## PLANNING CONSULTATION RESPONSE

| <b>Application No</b>             | 2026/0275                                                                               |
| <b>Proposal</b>                   | 2026 0275 3 Two Storey Side and Single Storey Front Extension Cliff Hill Lane Cawthorne |
| <b>Consultee</b>                  | Tony Wiles Senior Conservation Officer                                                  |

SOUTH ELEVATION  
1:100

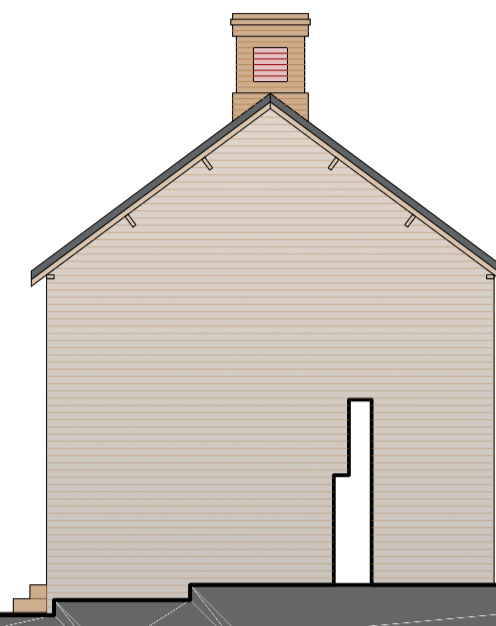
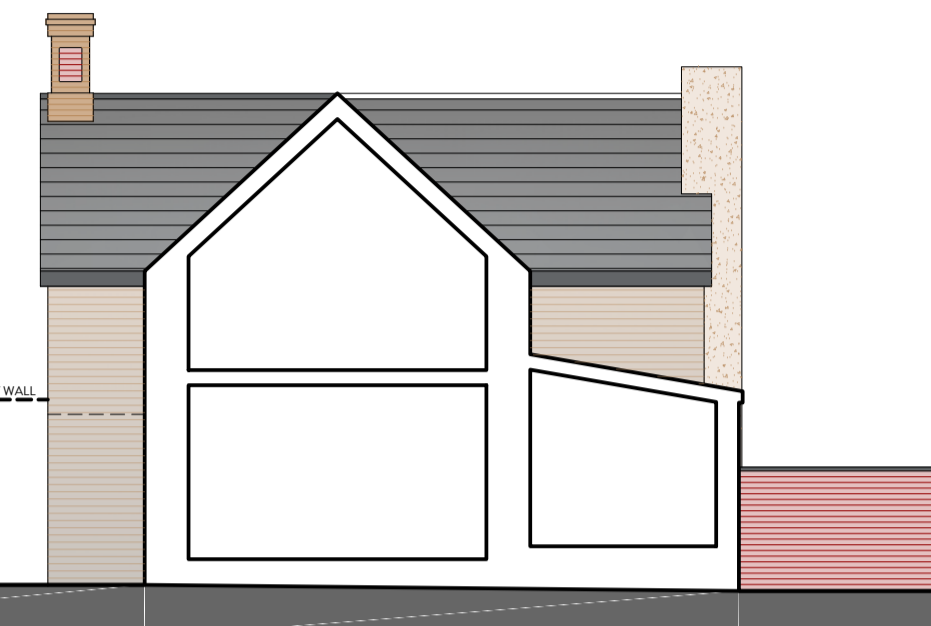
The proposal seeks permission for extensions to the south and west elevations, comprising a two-storey gabled projection to the south gable and a single-storey flat-roofed addition to the west. At present, a pergola and vegetation partially screen the existing ground-floor utility window. Having regard to the contribution the dwelling makes to the character and appearance of the conservation area, and to the overall form of the proposed development, I raise no objection in principle. The side gabled extension appears subservient in scale and massing, while the flat-roofed utility/workshop element, incorporating a rooflight, is positioned in a relatively discreet location with limited visibility from the public realm. I acknowledge that the scheme would result in a very minor degree of alteration to the historic fabric and envelope of the building, including the formation of new openings at ground and first-floor level to provide access to the extension, together with the lowering of the existing window opening behind the pergola to form a doorway. On balance, I do not consider this level of intervention to be unacceptable in principle. My principal concern relates instead to the proposed use of vertical timber cladding to the walls of the extension. This treatment is more commonly associated with agricultural buildings, such as Yorkshire boarding, and is not characteristic of domestic buildings within the locality. While such a material might potentially be acceptable for the single-storey flat-roofed element, I have reservations about its use across the full height of the two-storey gabled extension, where it would be more readily apparent. Both the material itself and its dark colour finish appear at odds with the prevailing palette of the area. In Cawthorne, the established materials are principally stone, brick and, to a lesser extent, render, as set out in the Neighbourhood Development Plan (Policy C7.3 and supporting text at paragraph 4.3.8), the Cawthorne Village Design Statement (page 6), and the adopted conservation area appraisal (paragraph 6.02). In my view, the two-storey gabled extension, which would be partly visible from Cliffe Hill, should therefore be constructed in materials that are more sympathetic and appropriate to the character and appearance of the conservation area.

Beyond the materiality I have no major objection but feel the issue of the timber cladding should be addressed and justified before I can support the proposal and agree it accords with S72(1), HE1 and the guidance mentioned above.

Following further discussions, and a revision to the design I advised I was comfortable with the design.

We have now received details of the materials which are acceptable. No further issues, comments, or objections.
